# TIERRA WEST, LLC

September 26, 2024

Responses to Comments on Retail at 7 Bar Conceptual Grading Plan and Conceptual Drainage Report. Hydrology File: B14D010D

Figure 5 - Street Hydraulic Conditions

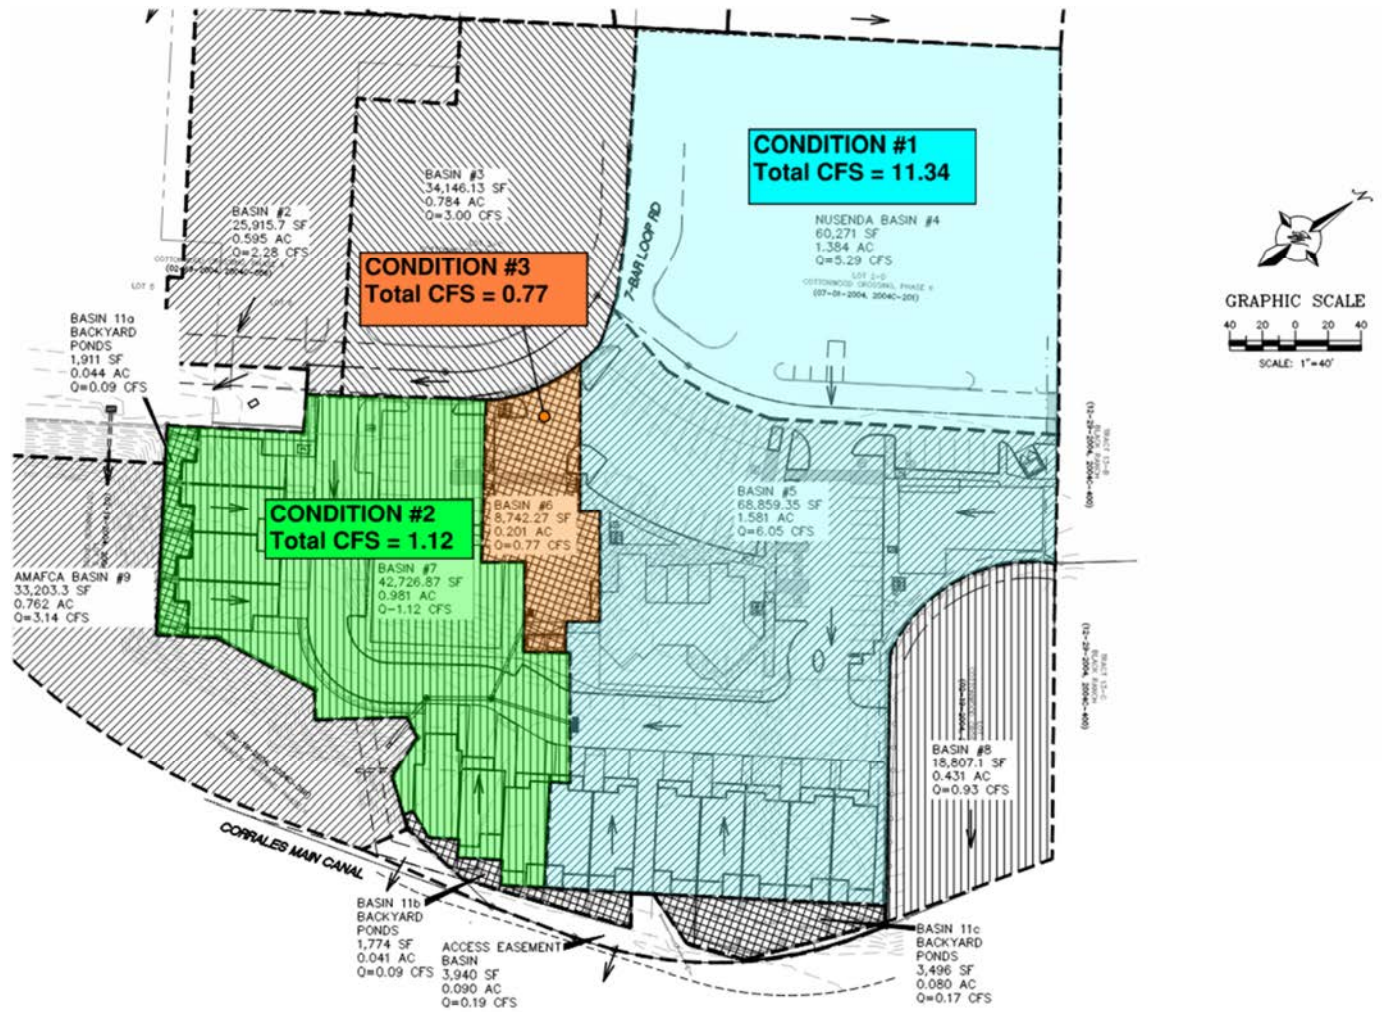
1. Page 15, Figure 5 – Street Hydraulic Conditions shows Basin #3 stormwater runoff potentially diverted into Basin #2 at the western entrance to the development which may increase the total Q (cfs) for Condition #2.

2. Page 15, Figure 5 – Street Hydraulic Conditions shows Basin #7 with a flow arrow over the top of bank of the AMAFCA Pond.

3. Page 15, Figure 5 – Street Hydraulic Conditions shows Basin #6 with contributing drainage area over a wall just north of the south access roadway.

***1. Response – Boundary for Condition #2 was revised to coincide with Water Block shown at entrance to TH's (Basin 7).***

- ***Weighted E Table was updated to reflect the updated SF's of the revised basin.***
- ***Conceptual G&D Plan was updated with revised applicable flows as a result of basin changes.***
- ***There were no changes to the overall 100yr volumes or flows going into the AMAFCA pond as a result of the reconfigured basin limits.***
- ***Associated changes to Street Hydraulic Calculations and Cross Sections were updated as a result of the minor basin changes.***

***1. Response – Flow Arrow was removed from the drawing. It was intended to show the conveyance from the penetration into the pond along the new SD.***

***1. Response – Basin area has been revised shifting the eastern boundary west in line with the Conceptual G&D Plan. The difference of which is added to Basin #7. All applicable items have been updated.***

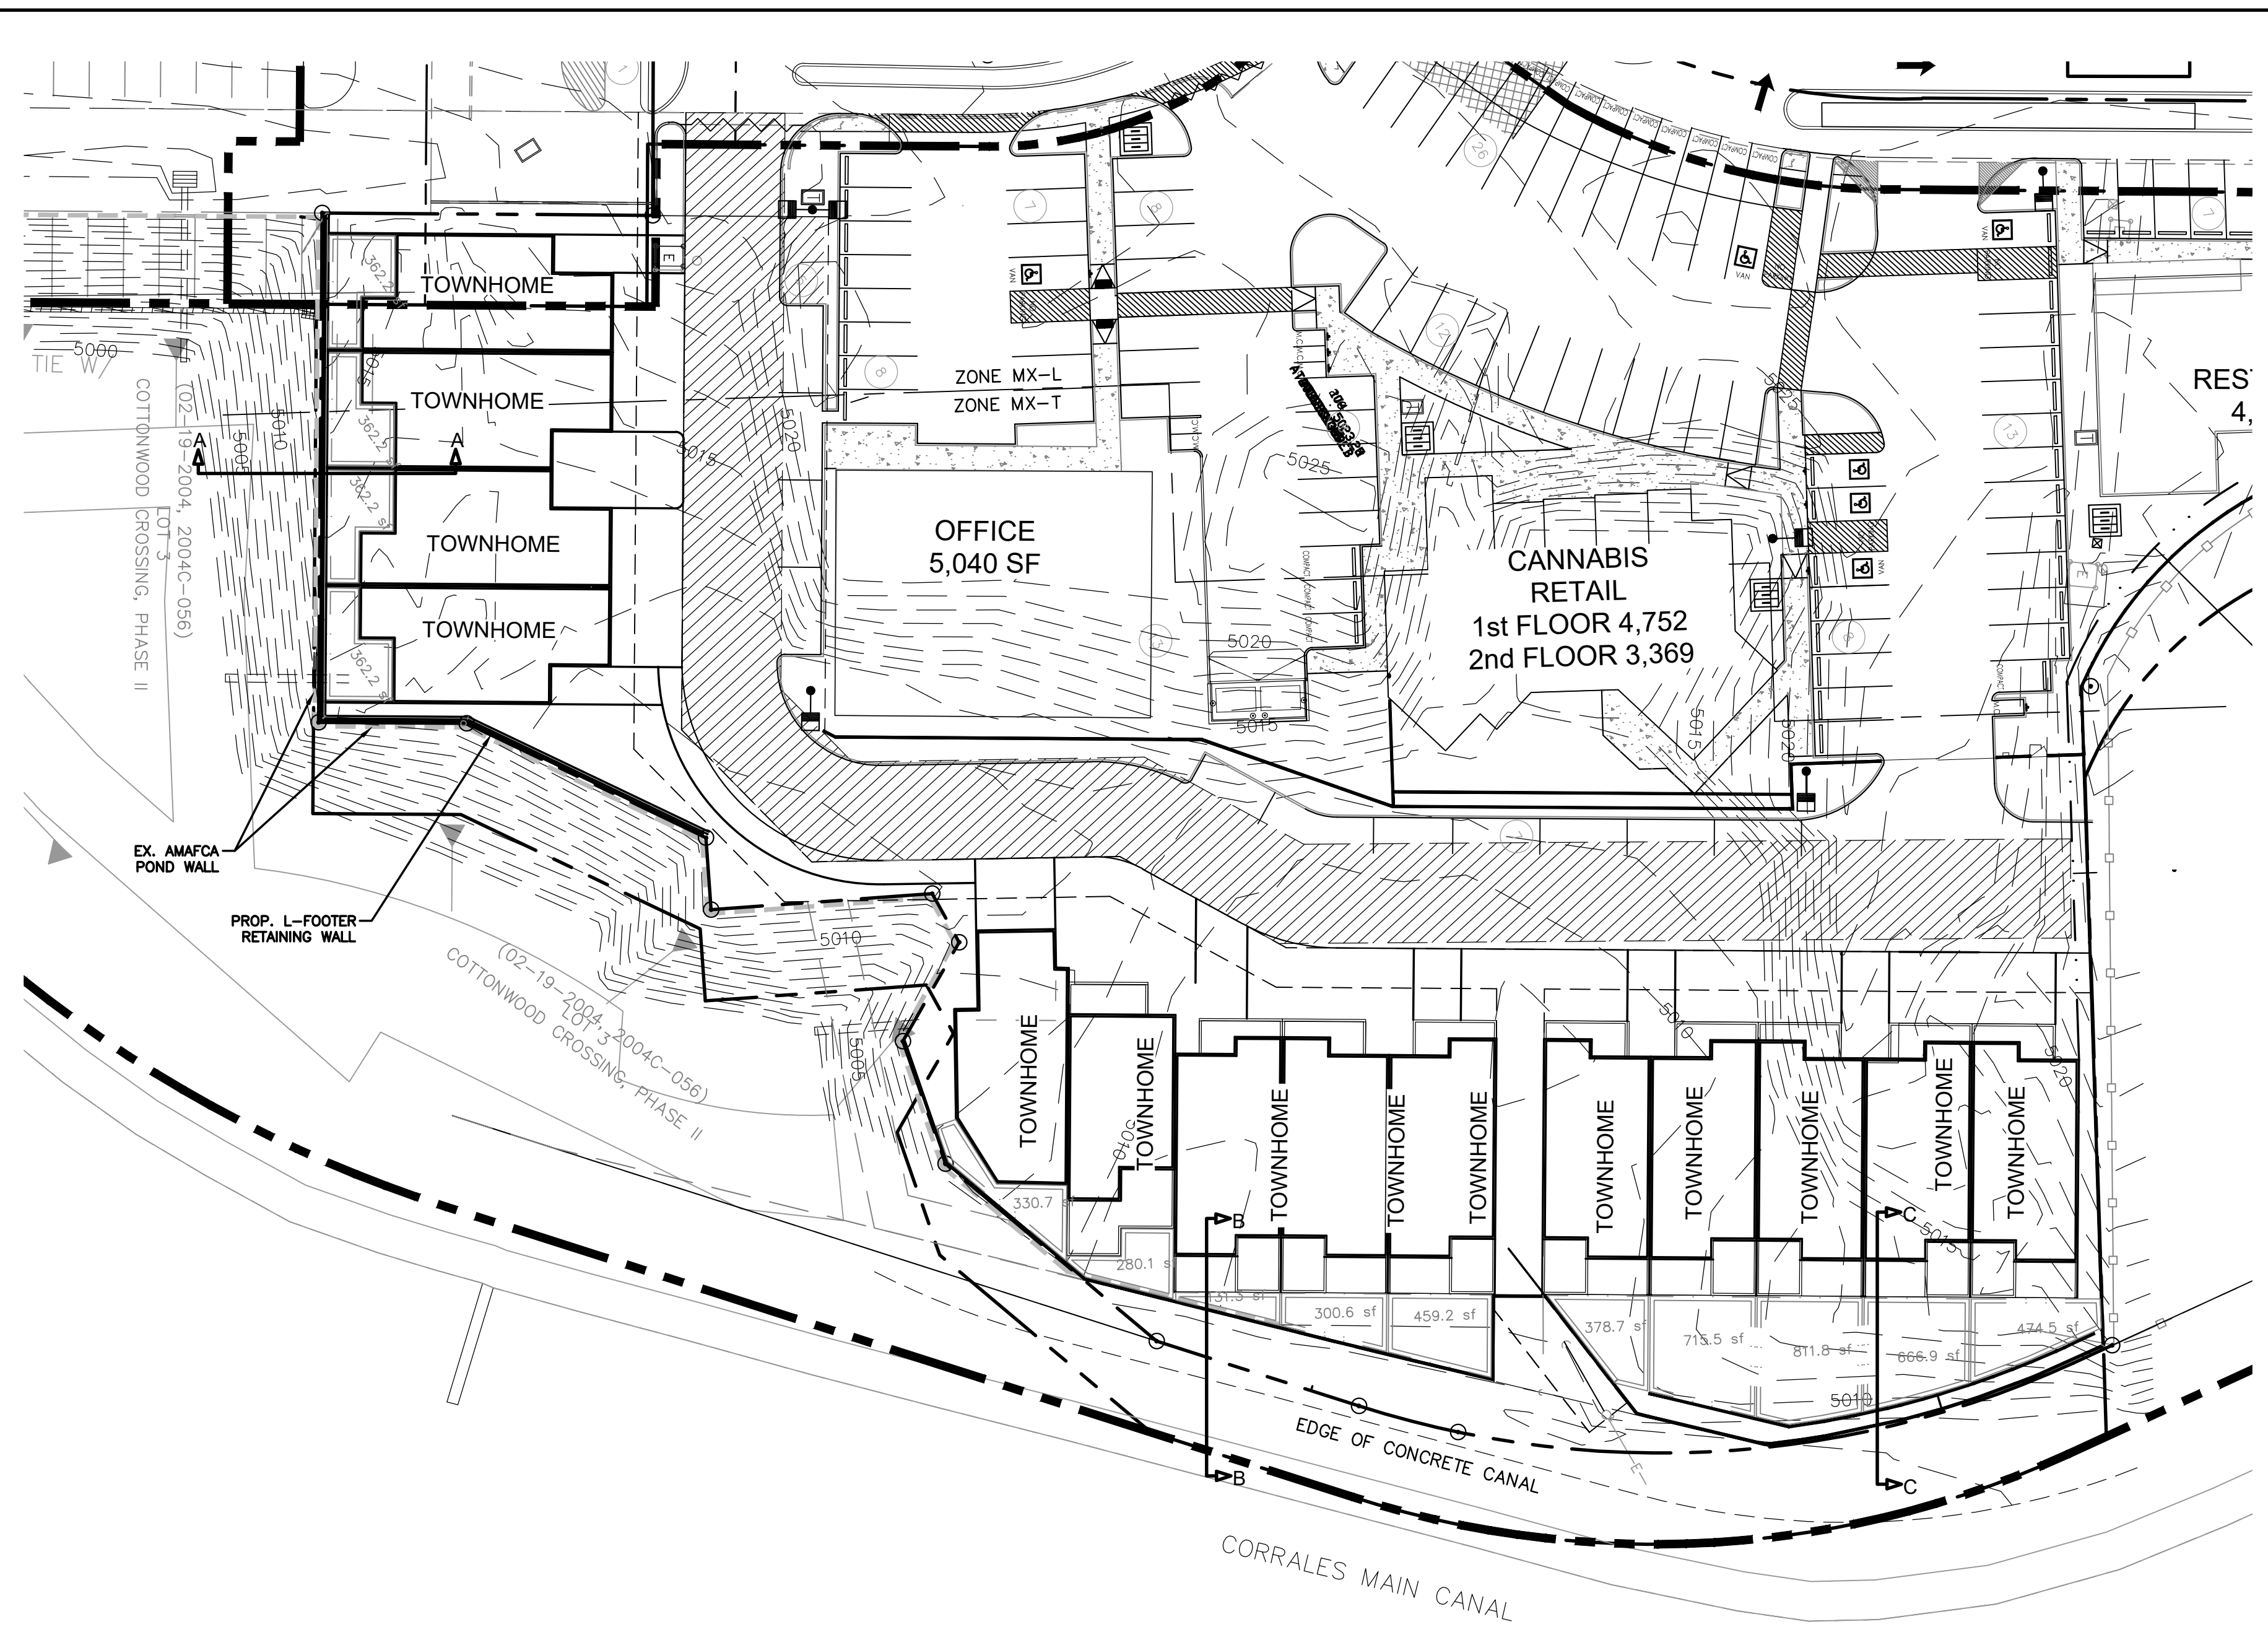
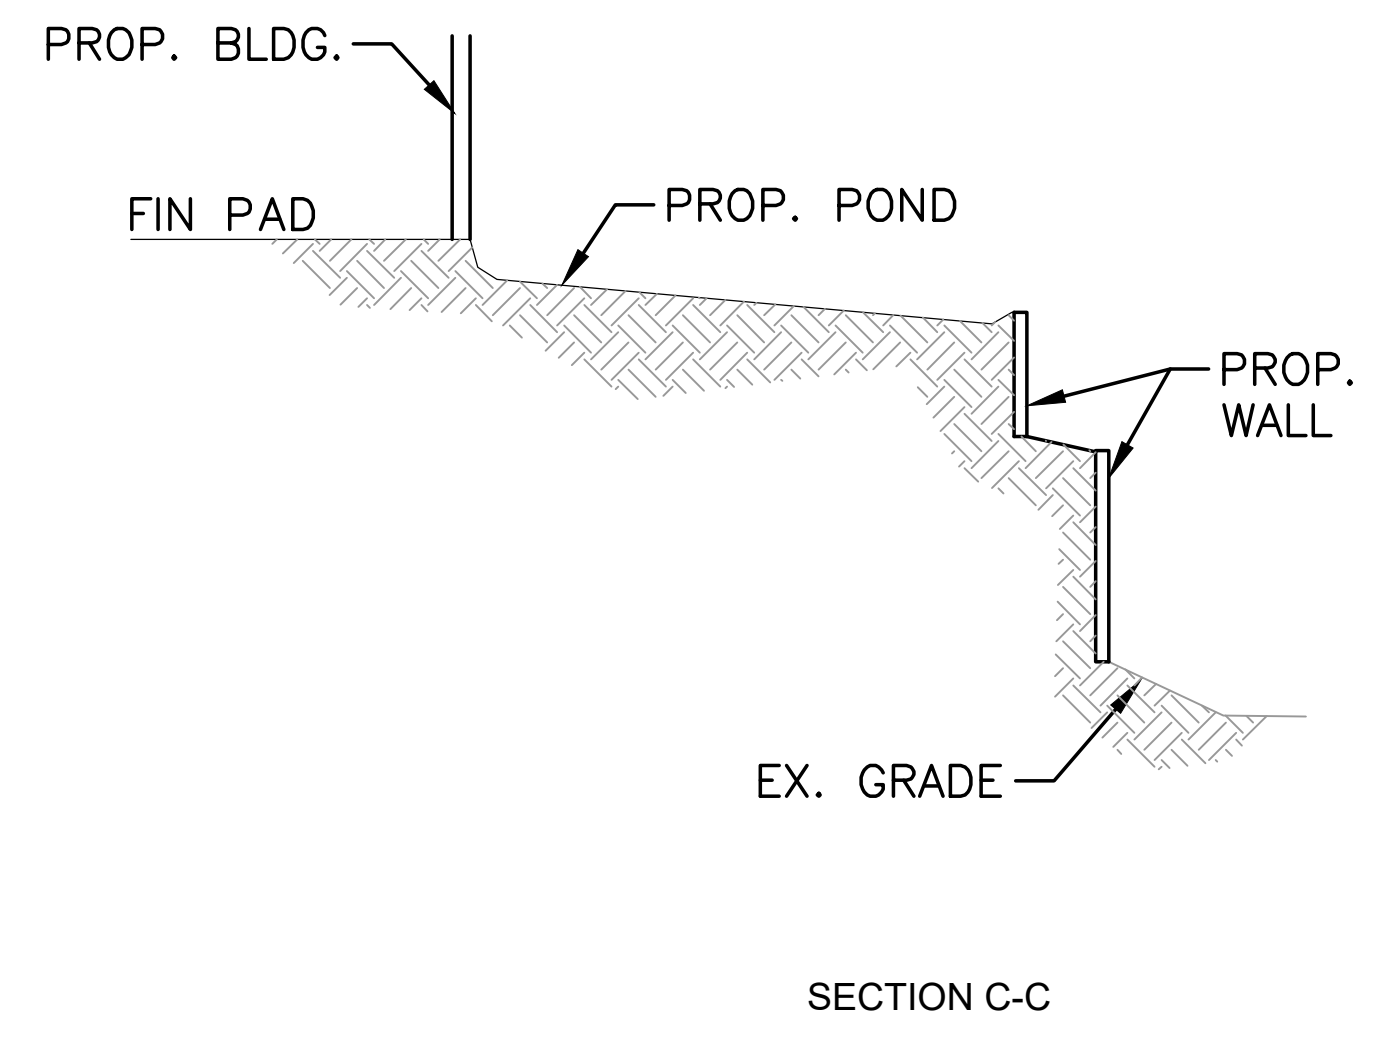
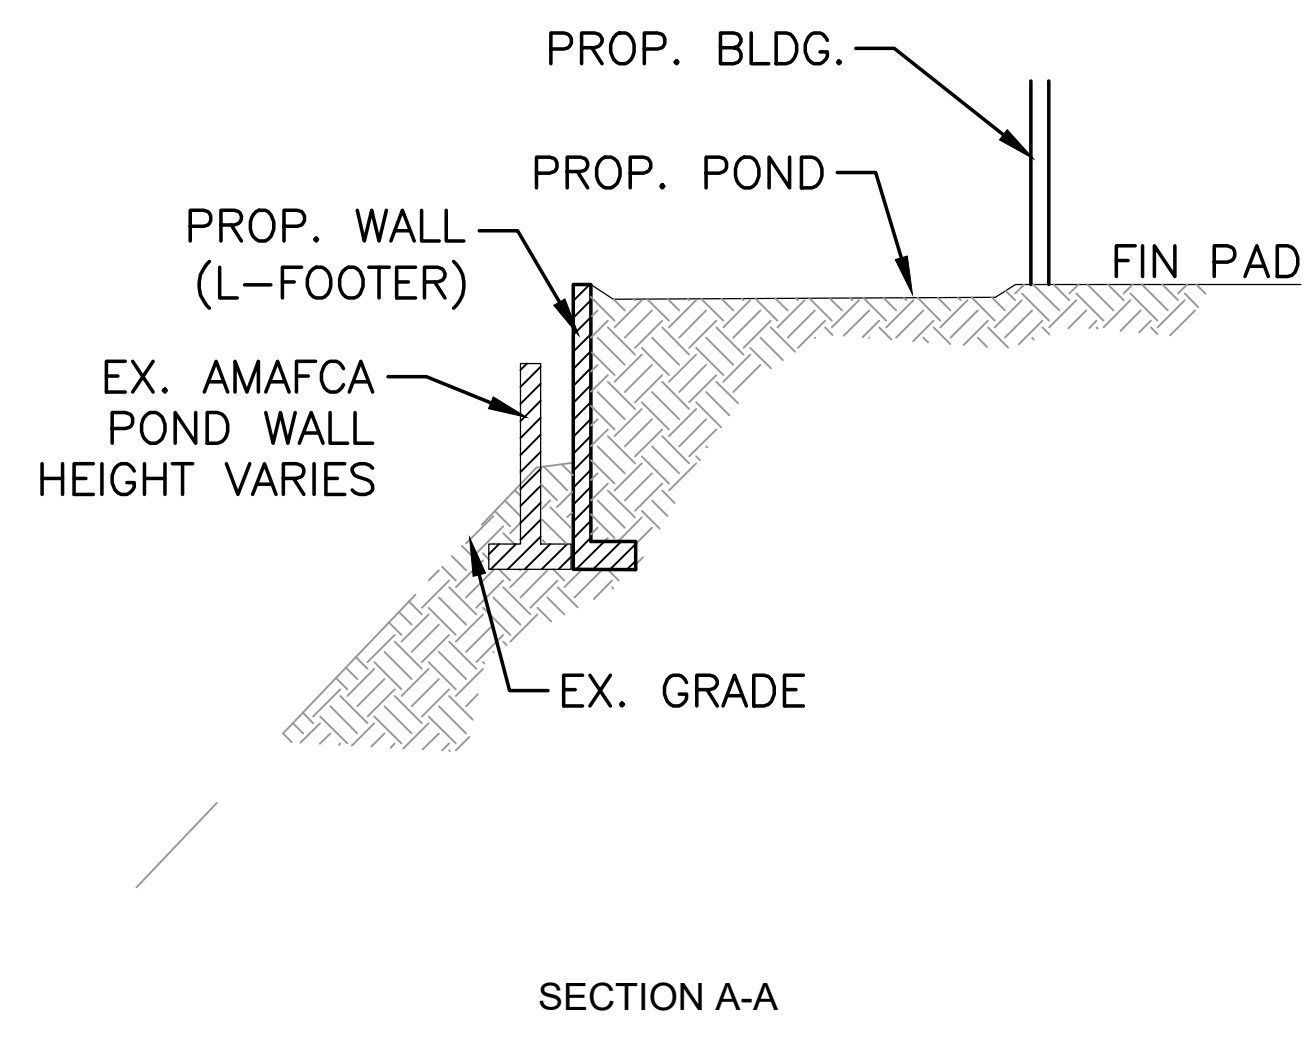
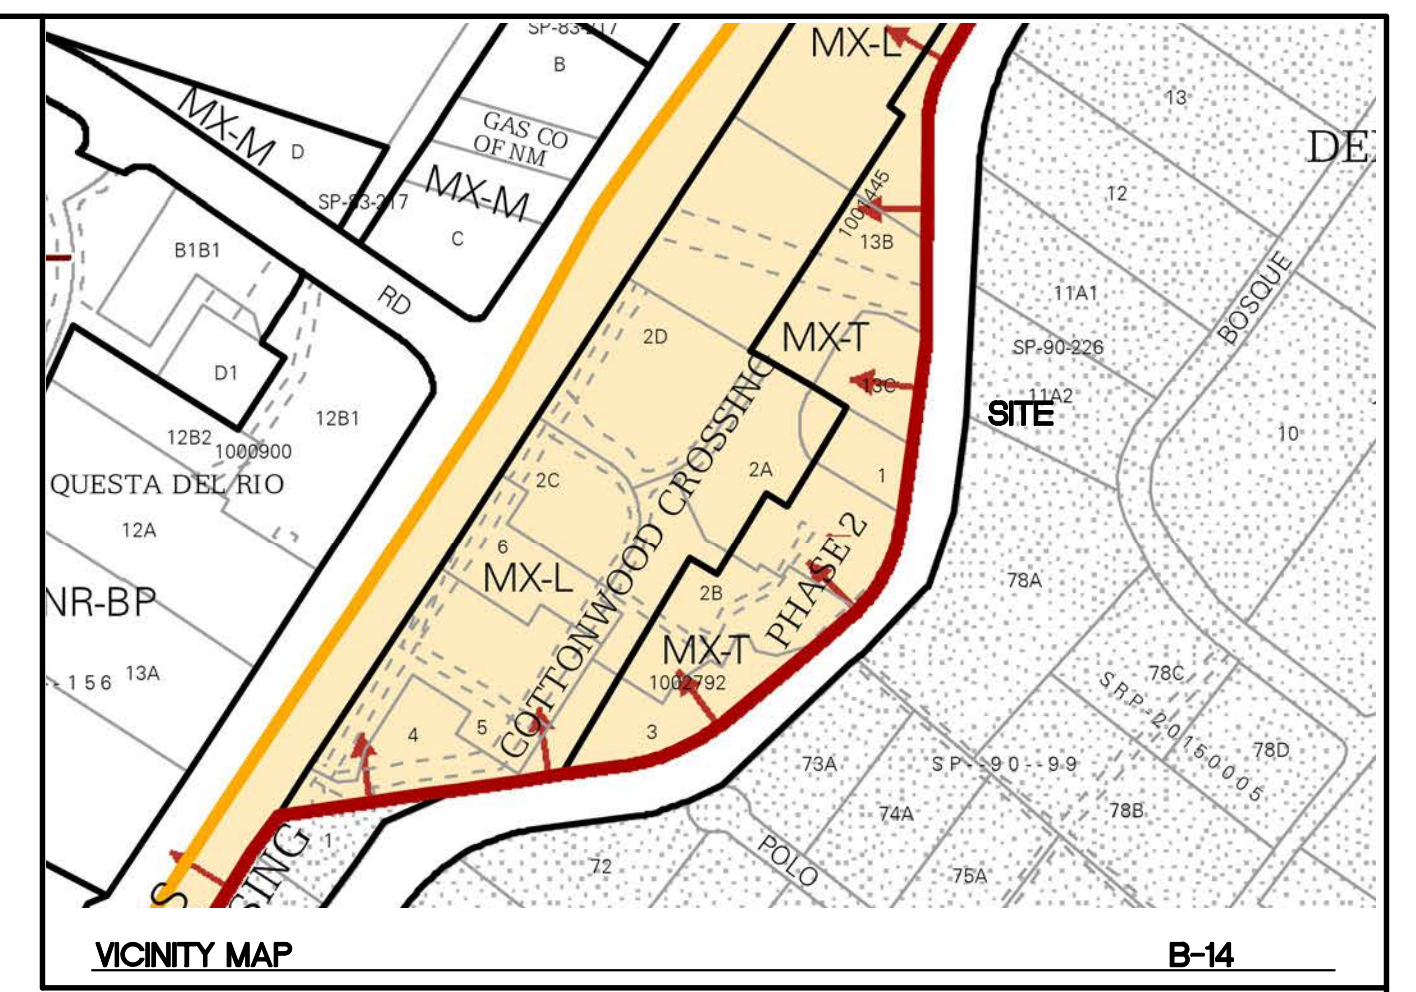
2. Townhomes 1-4 show Finished Floor (FF) elevations equal to adjacent Top of Wall (TW) elevations which conflicts with Section A-A on Sheet EX-1, Cross Sections at Pond and at Channel, that show Pad Elevations equal to adjacent Proposed Top of Walls. Clarification / correction should be provided.

- 1. Response – The cross sections have been revised to show the FF elevations, cross section detail incorrectly called for finished pad.**
